Application Ref:	3/2026/0382			 Ribble Valley Borough Council www.ribblevalley.gov.uk
Date Inspected:	26/06/26	Site Notice:	26/06/26	
Officer:	LW			
DELEGATED ITEM FILE REPORT:				REFUSAL

Development Description:	Proposed second floor extension to rear to provide additional Class E space, alterations and creation of new window and door openings.
Site Address/Location:	10 King Street, Clitheroe, BB7 2EU.

Ground Floor Plan  
1:100 Scale

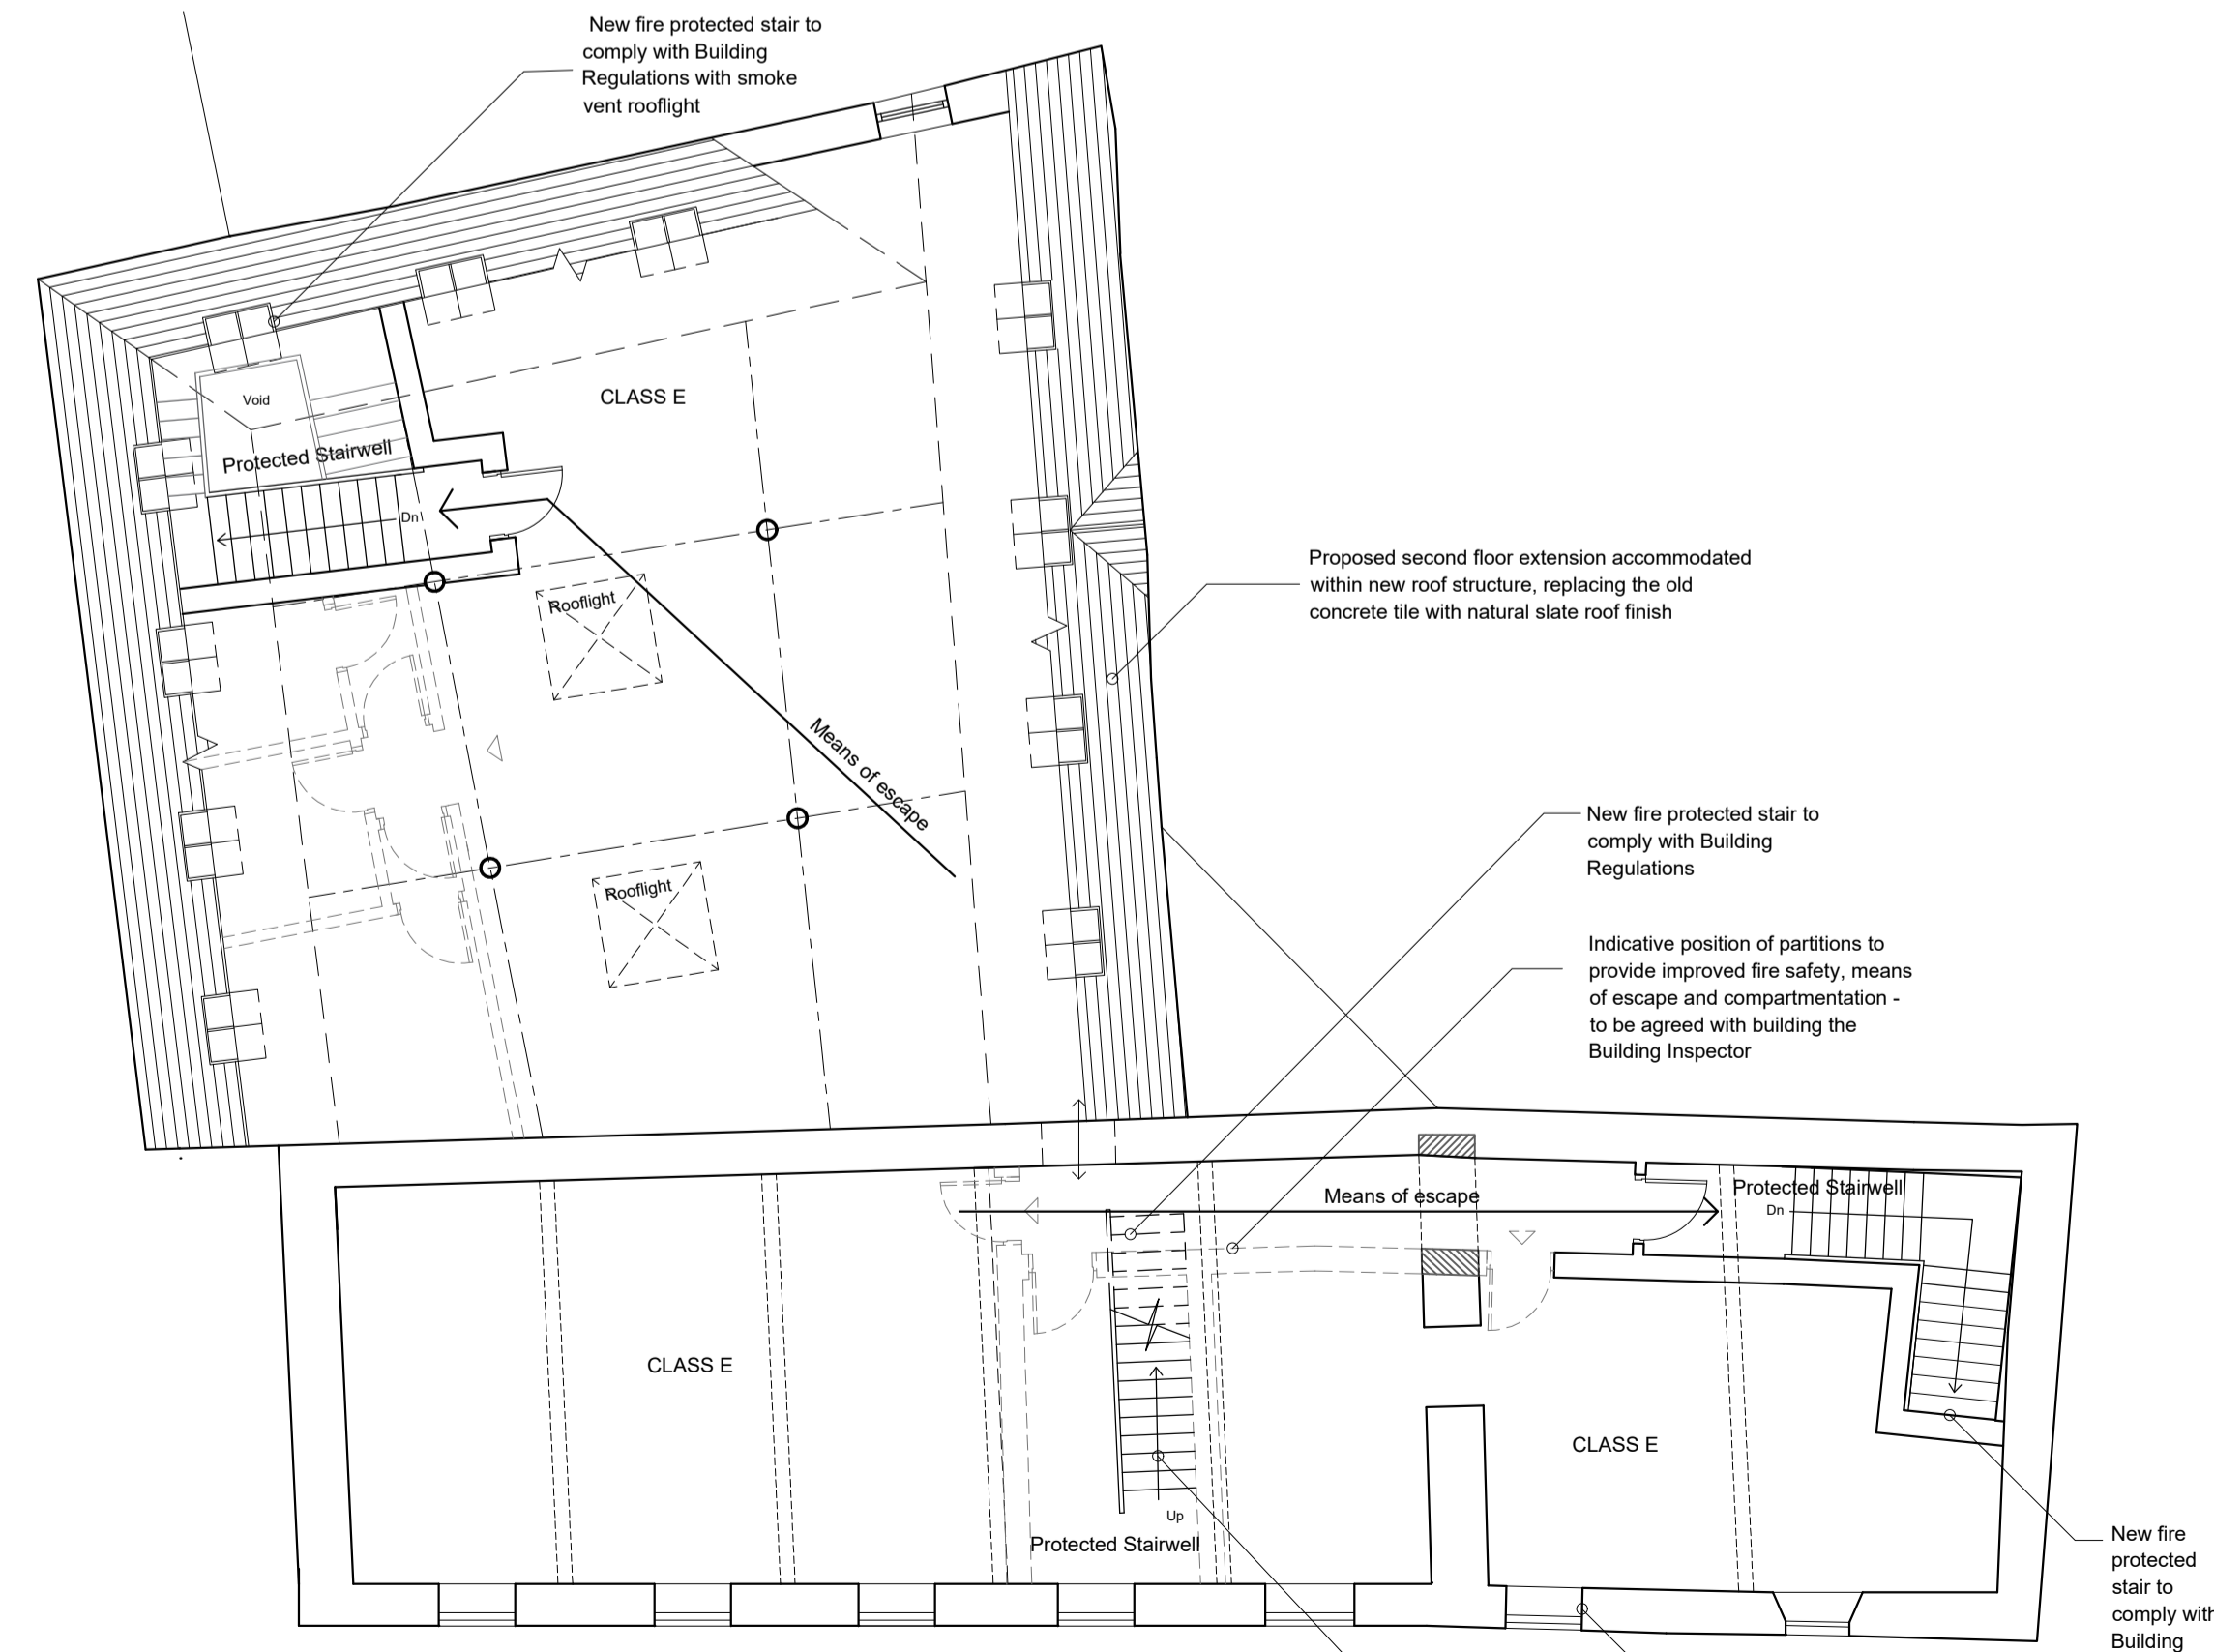
The proposed additional accommodation would be largely created within the roof space of the existing rear projection. The development would involve an increase in the overall ridge height of approximately 2 metres and an increase in the eaves height of approximately 0.4 metres. The extension would incorporate a total of 13 conservation-style rooflights, comprising 11 rooflights within the pitched roof slopes and a further two rooflights within the flat roof section. A gabled

The proposed extension would substantially alter the appearance of the existing structure. The increased ridge height, steeper roof profile and the introduction of numerous new window openings and rooflights would significantly change the character of the building. In particular, the quantity of window openings and rooflights and enlarged roof form, would introduce a more domestic appearance that would be at odds with the simple, utilitarian character currently exhibited by the building.
